Need to update Letter of Intent to include the following waivers from the Land Development Code

FILE NO. SF2315

MARIAH TRAIL FILING

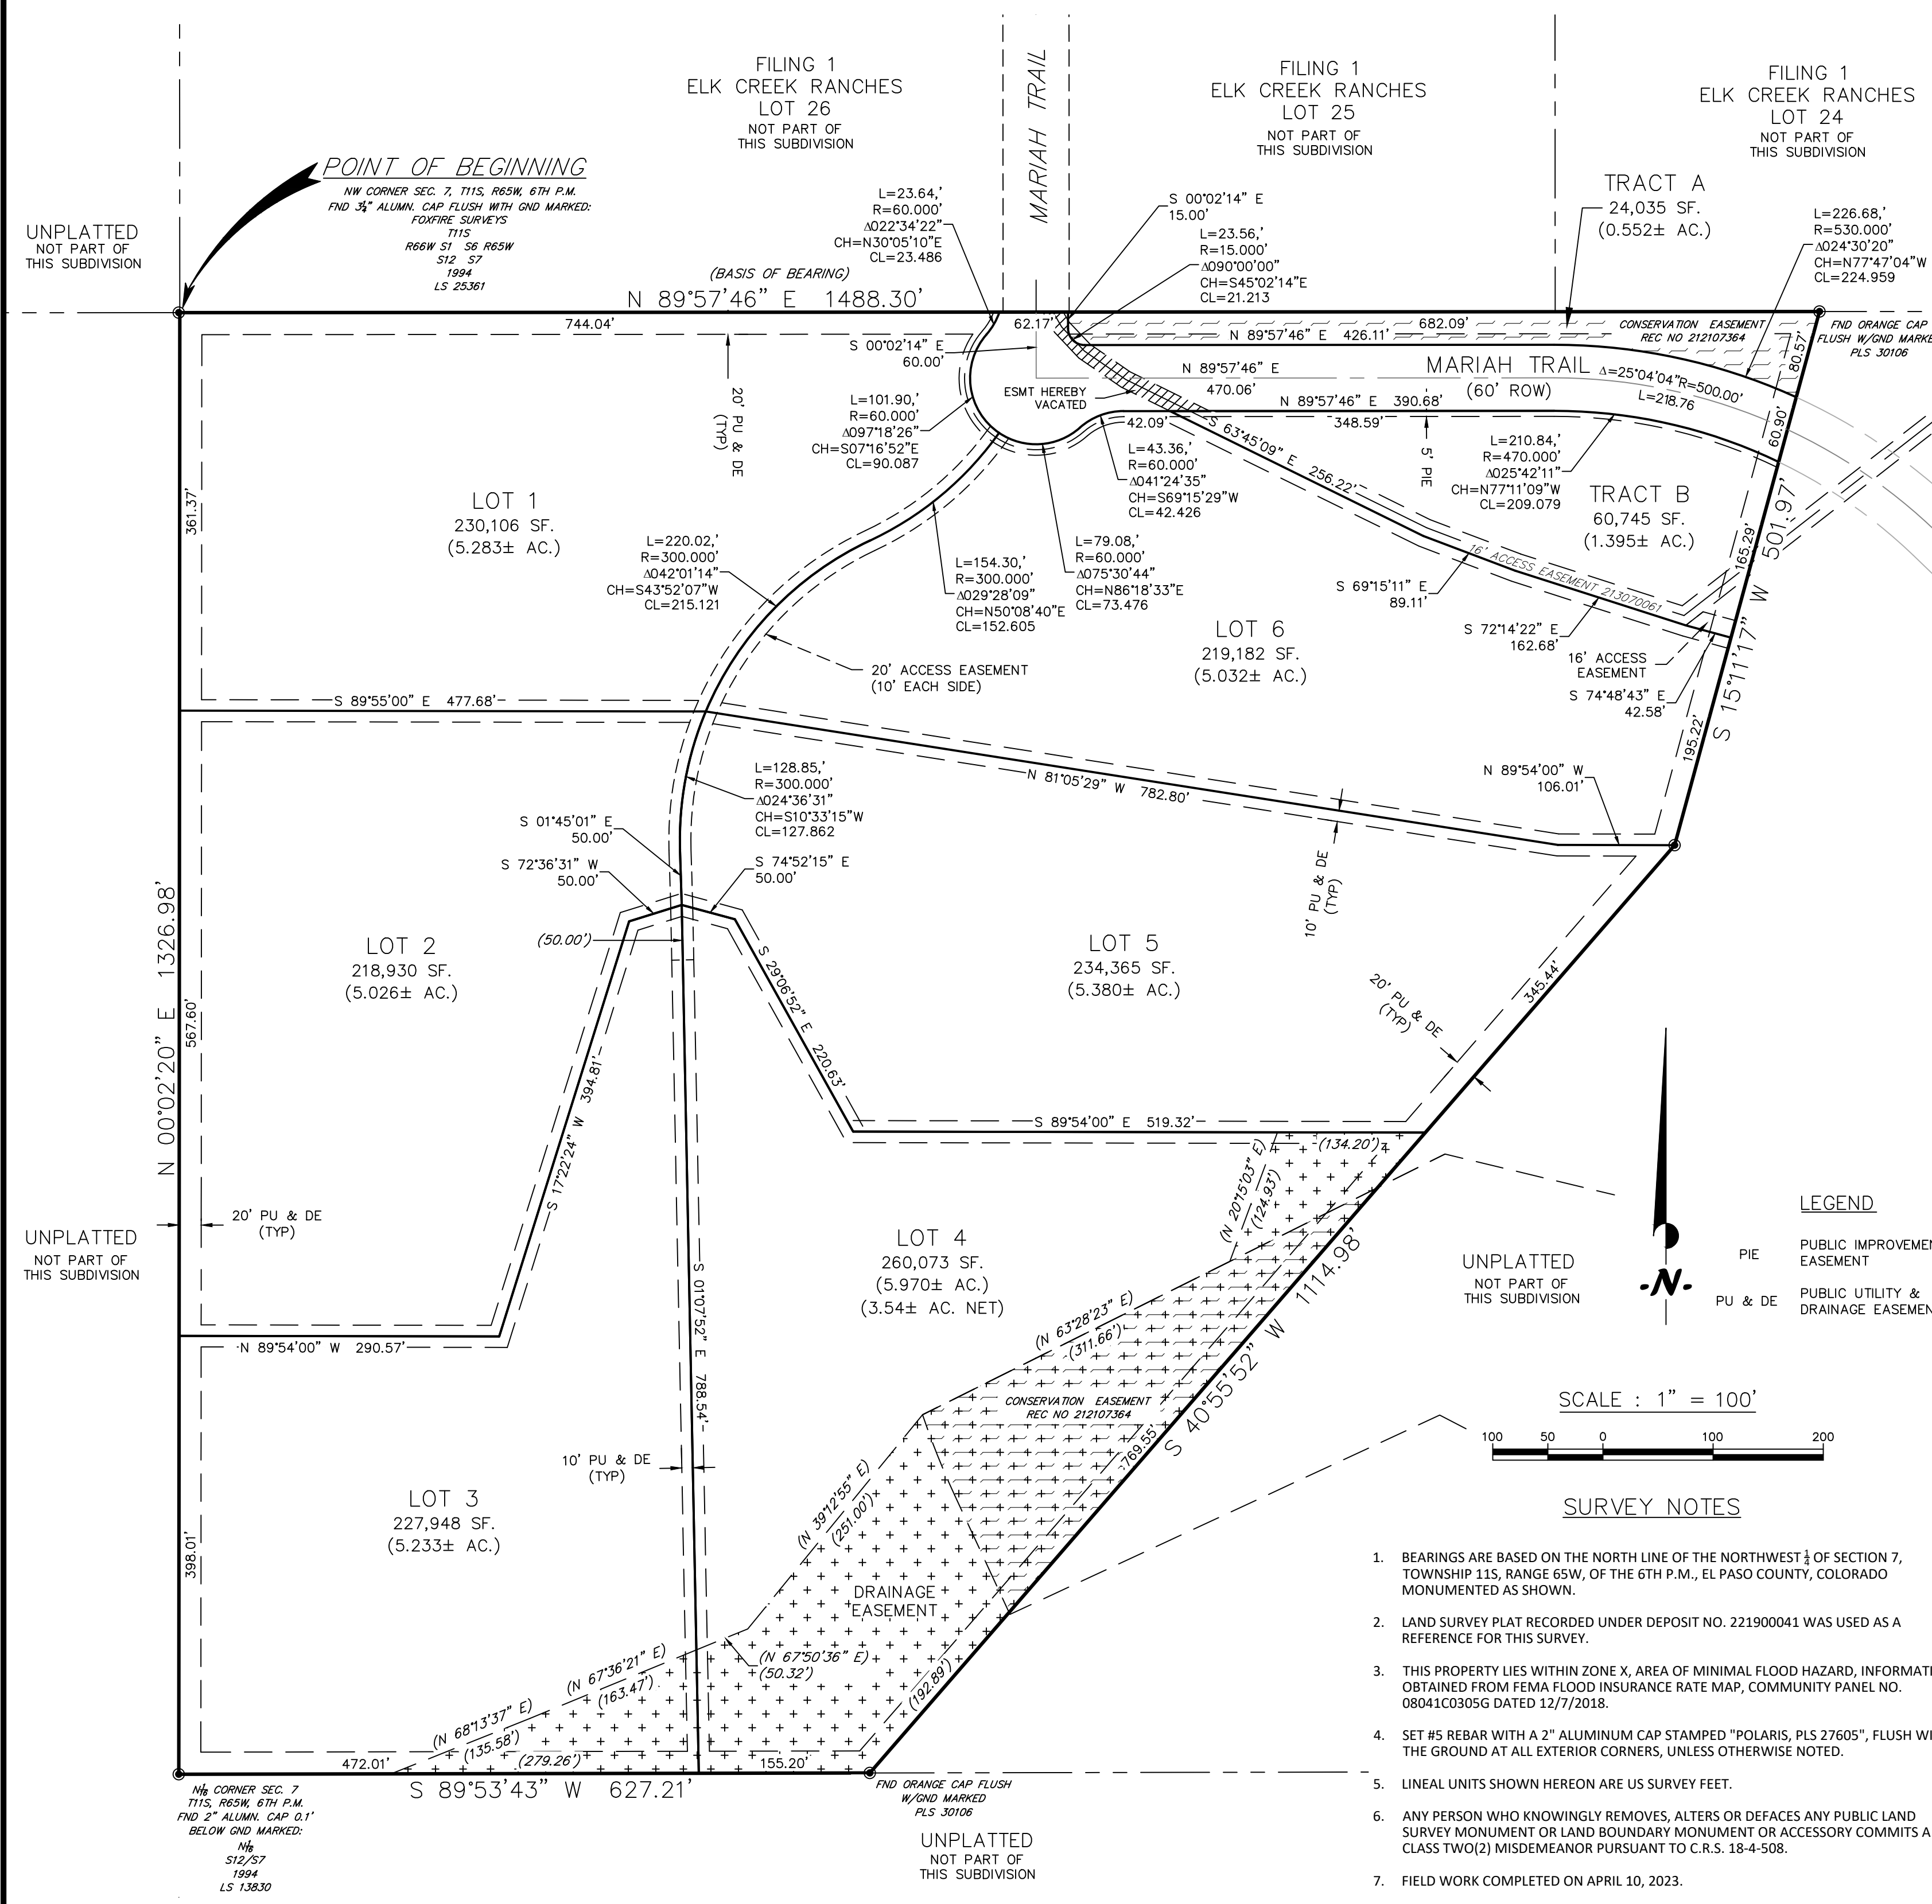
Conservation easement cannot be vacated as shown on CD

revise radius at knuckle to 37' min. per County standard detail and include a non revocable public improvement easement (see ECM 2.3.8.C) for any portion of the cul-de-sac that is outside the ROW.

Also per planners comment, roadway may need to be extended further south to avoid the conservation easement.

FYI: this does not have to be dedicated ROW and can be a preservation.

Add a note to the plat acknowledging that per ECM Section 1.7.1.B.5, the residential lots impervious area may not exceed 10 percent unless a study is prepared in compliance with the requirements laid out in the above ECM Section and the impervious area may not exceed 20 percent. This impervious area for each lot must include the proposed driveway.
